REQUEST

Current Zoning: N1-A (Neighborhood 1-A)
Proposed Zoning: N2-B(CD) (Neighborhood 2-B, Conditional)

Approximately 7.17 acres located on the south side of York Road and west side of Youngblood Road.

The petition proposes to allow an age restricted multifamily stacked development with up to 160 dwelling units on a vacant parcel in the Steele Creek community.

JOB NO.  
**62387**  
SHEET NO.  
**RZ-1**

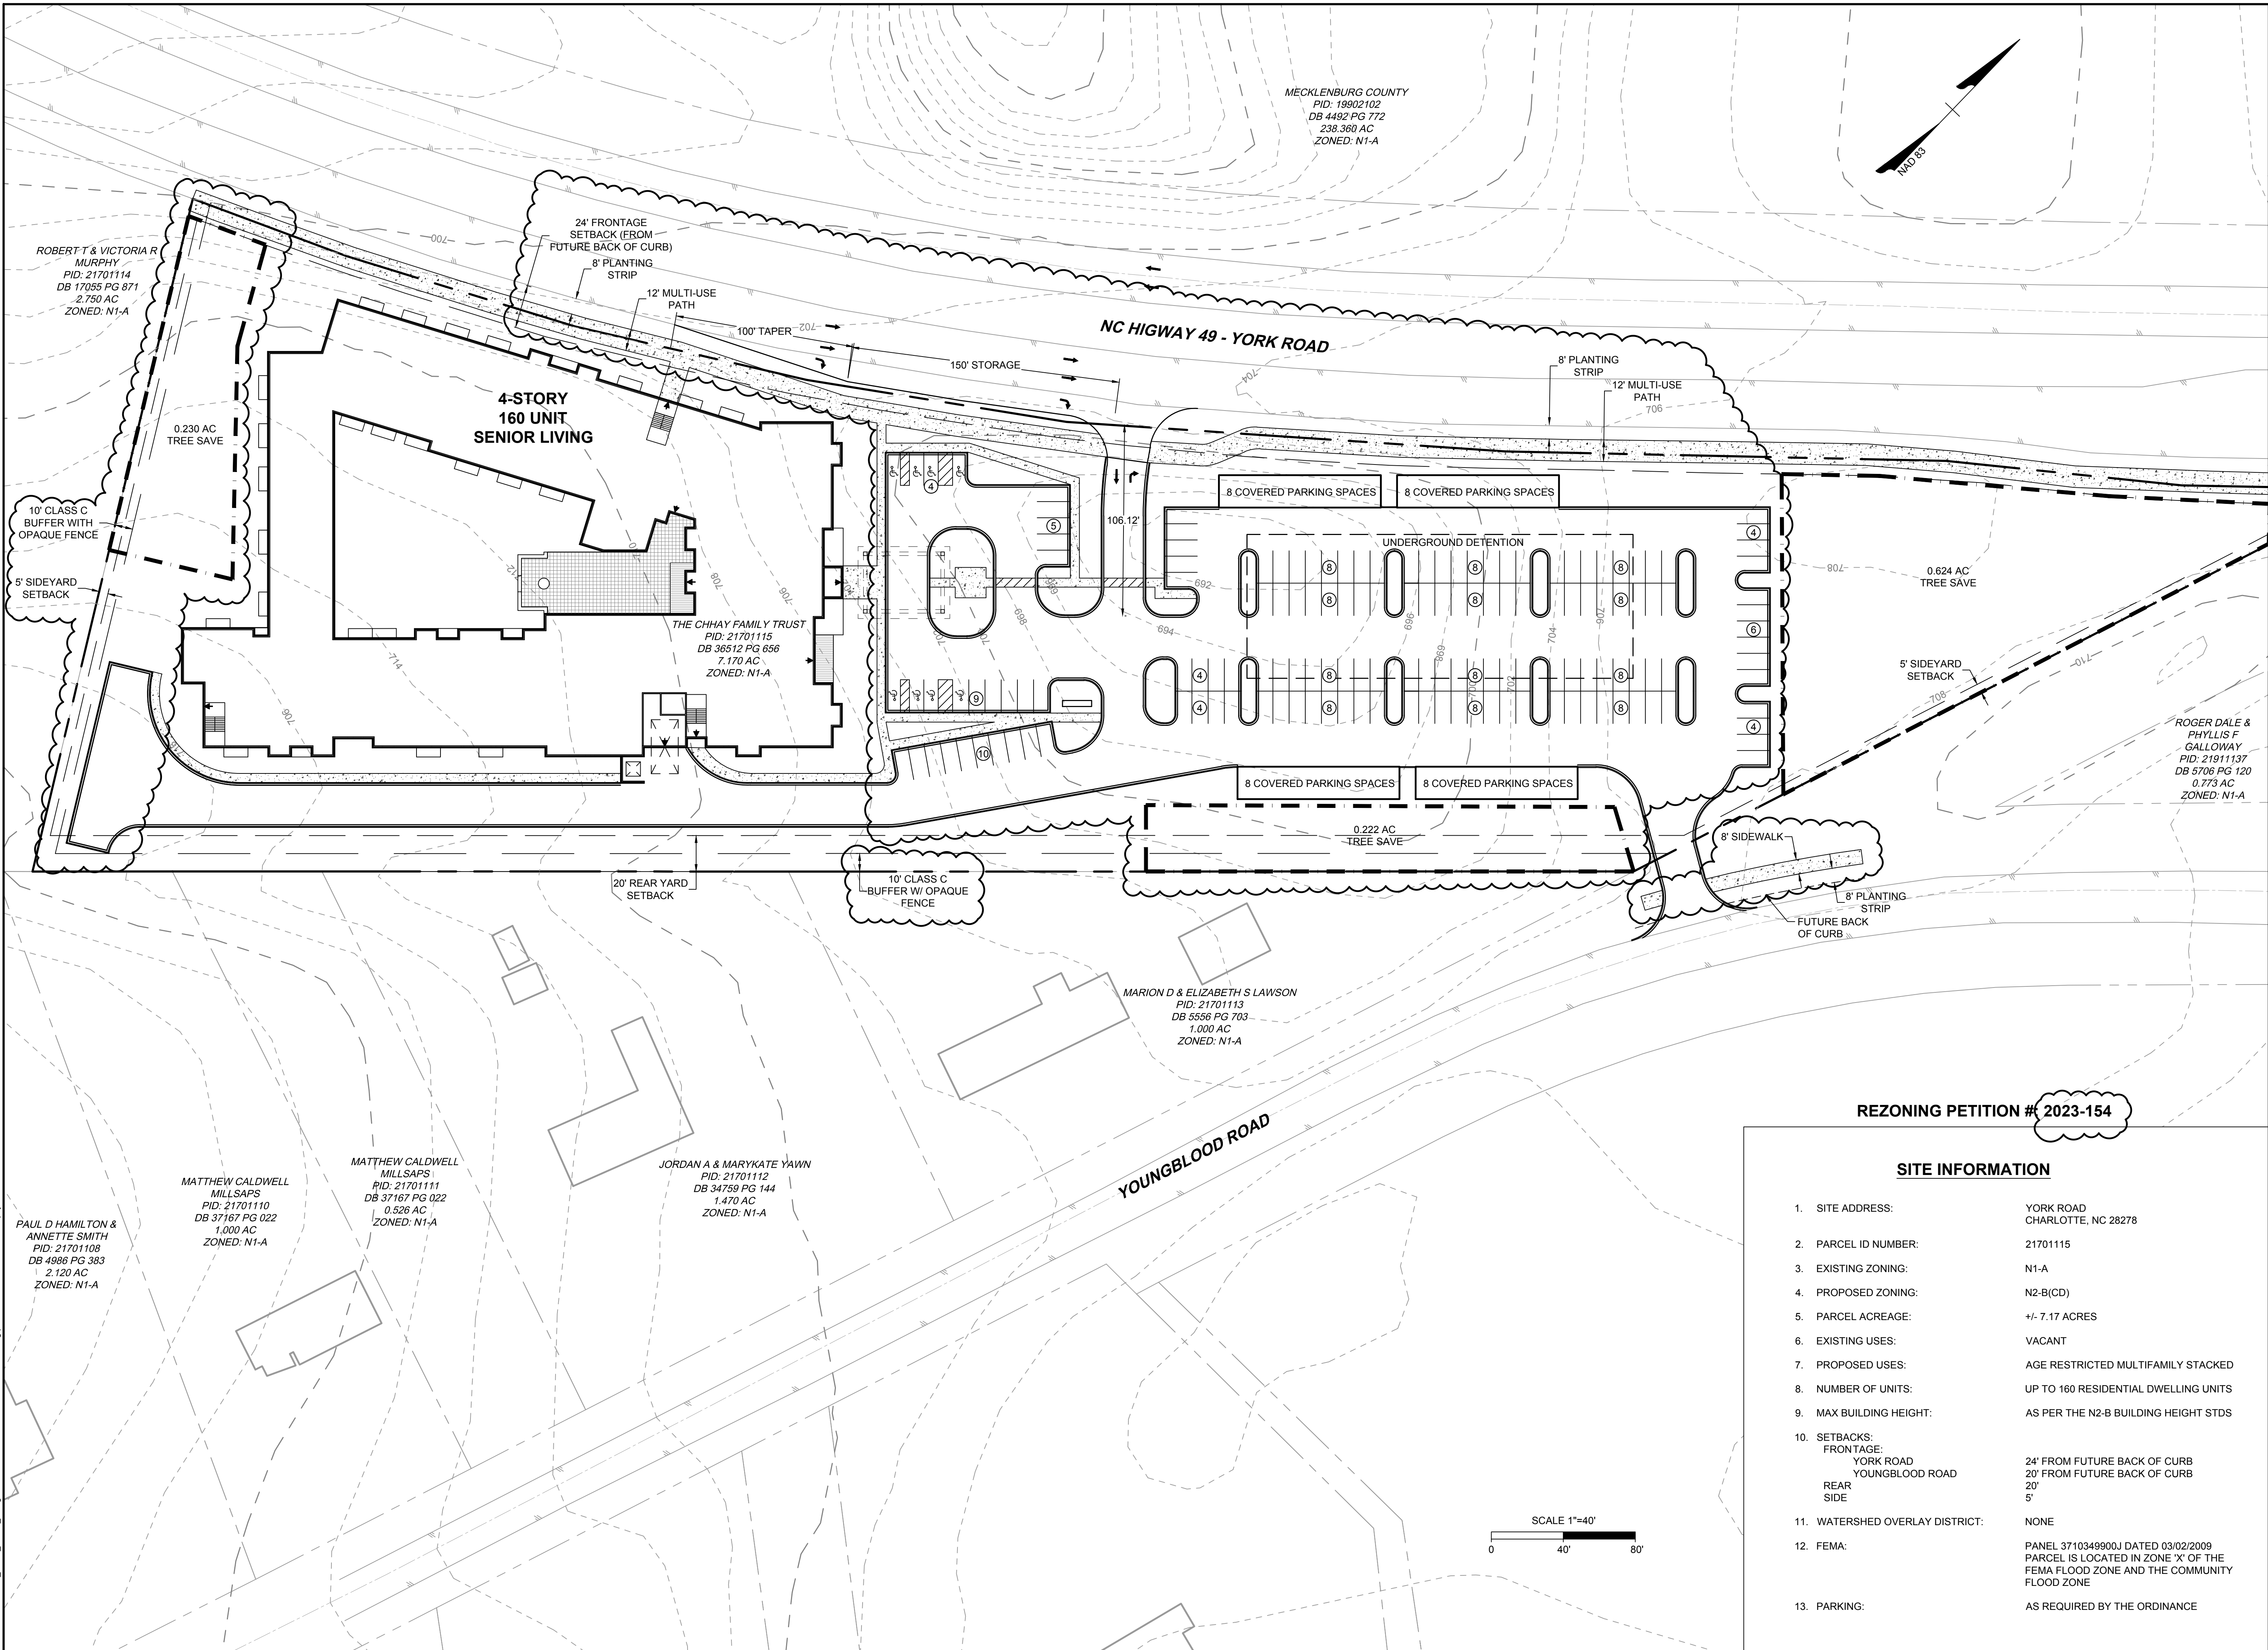
1. Commit to a 25' Class B buffer with opaque fence where adjacent to N1 zoning and place type.

2. Provide a tree survey showing all city trees 8" DBH or greater and all planted city trees, all existing heritage trees on site, and any existing areas of the site used for credit toward meeting previously approved tree save or green area requirements.
3. Verify that tree save areas are contiguous.

4. Label and dimension the curb and gutter from the centerline for each road on the site plan.
5. Label and dimension the right-of-way from the road centerline.
6. In coordination with NCDOT, revise site plan and conditional note(s) to show the existing driveway on the east side of Youngblood Road. Align the sites entrance along the centerline of the existing driveway.
7. Revise site plan and conditional note(s) to commit to restriping a left turn lane into the site off of Youngblood Road.
